CITY OF ALBUQUERQUE

October 16, 2018

RE: **Sicily Plaza**
6001 Coors Blvd NW
Request for Certificate of Occupancy - Temporary
Hydrology Final Inspection – Not Approved
Engineer's Stamp Date 12/7/17 (E12D003F)
Certification Dated: 10/10/18

ENGINEER'S SEAL  12/7/17 11/28/17 DAVID SOULE P.E. #14522	COMMERCIAL SHELL BUILDING AT SICILY PLAZA 6001 COORS BLVD NW	DRAWN BY WCWJ DATE 11-28-17 21823-LAYOUT-11-15-17
	GRADING AND DRAINAGE PLAN  1606 CENTRAL AVENUE SE SUITE 201 ALBUQUERQUE, NM 87106 (505) 872-0999	SHEET # JOB # 21823

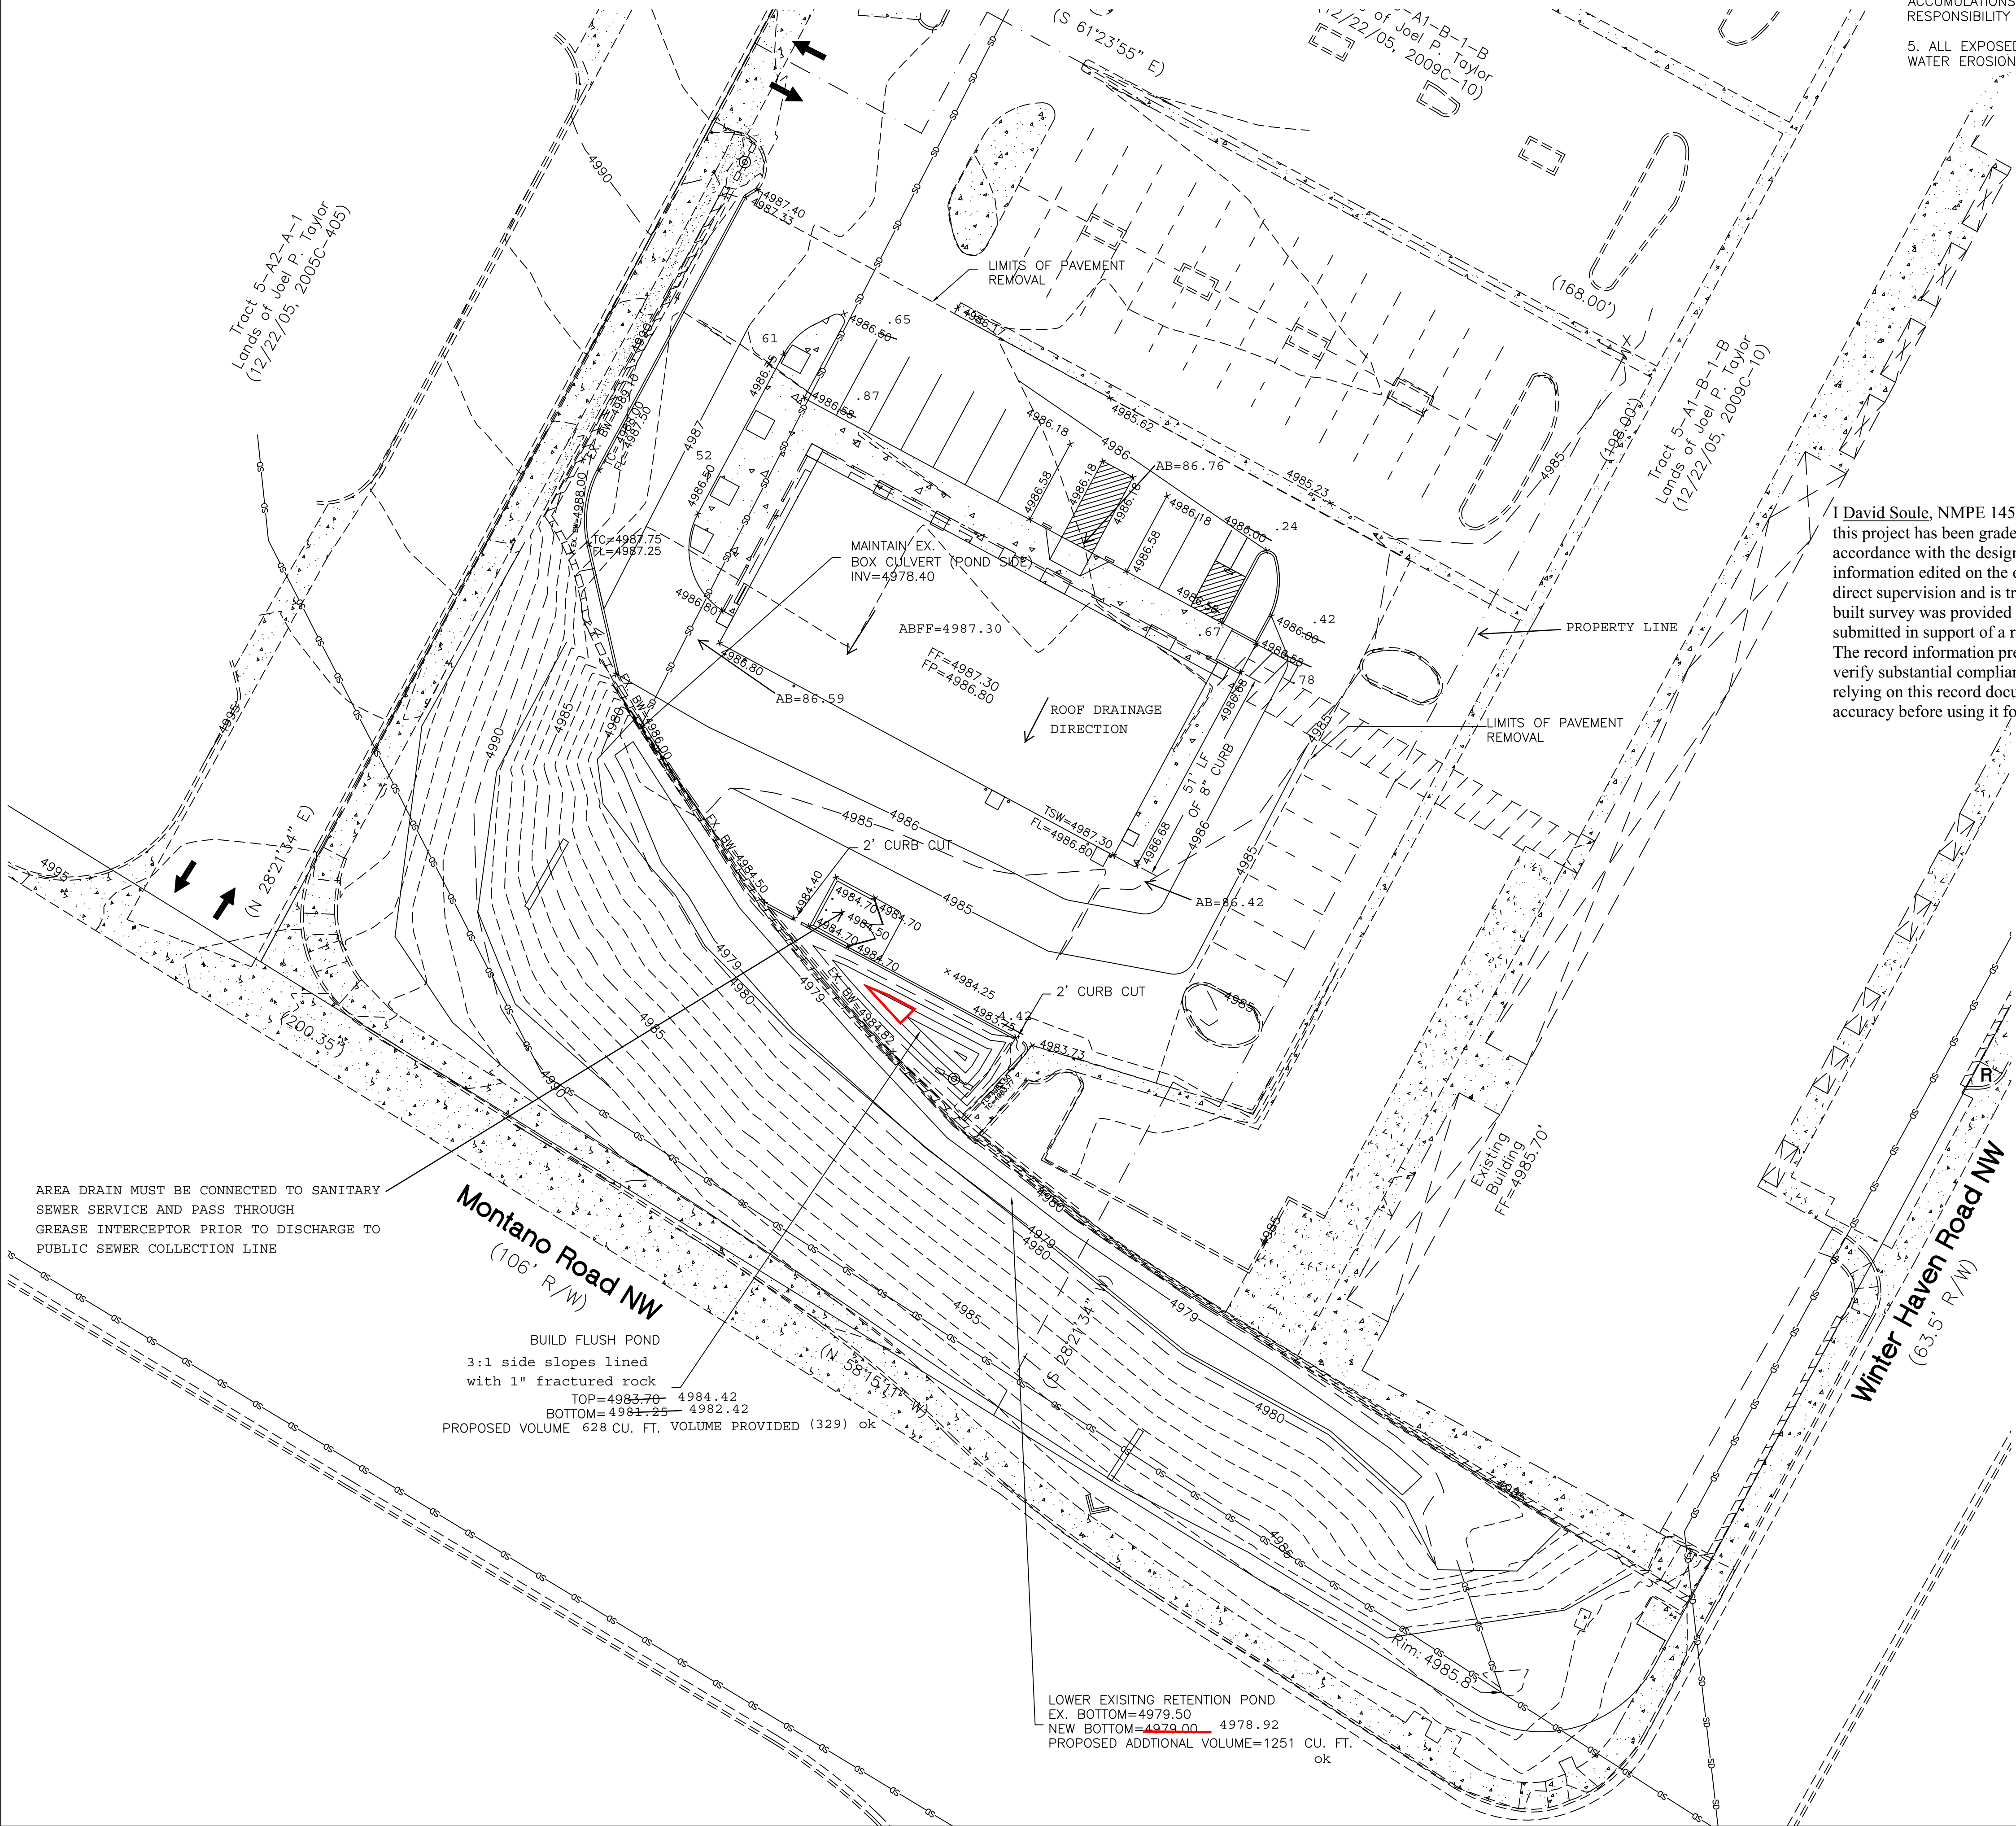
1. Temporary C.O's cannot be issued on shell permits; all corrections must be made so a Permanent C.O can be requested.
2. The Drainage Covenant will need to be recorded; provide a copy of the Bernalillo County Recorded Drainage Covenant.
3. Include as-built elevations for the bottom of the existing and new ponds with the Drainage Certification; the new bottom of the large pond needs to be surveyed.
4. The 628cf first flush pond needs to be constructed per plan including excavation to the proper depth and volume. The as-built condition of the pond needs to match the contours provided on the grading plan and be supported with new survey data.
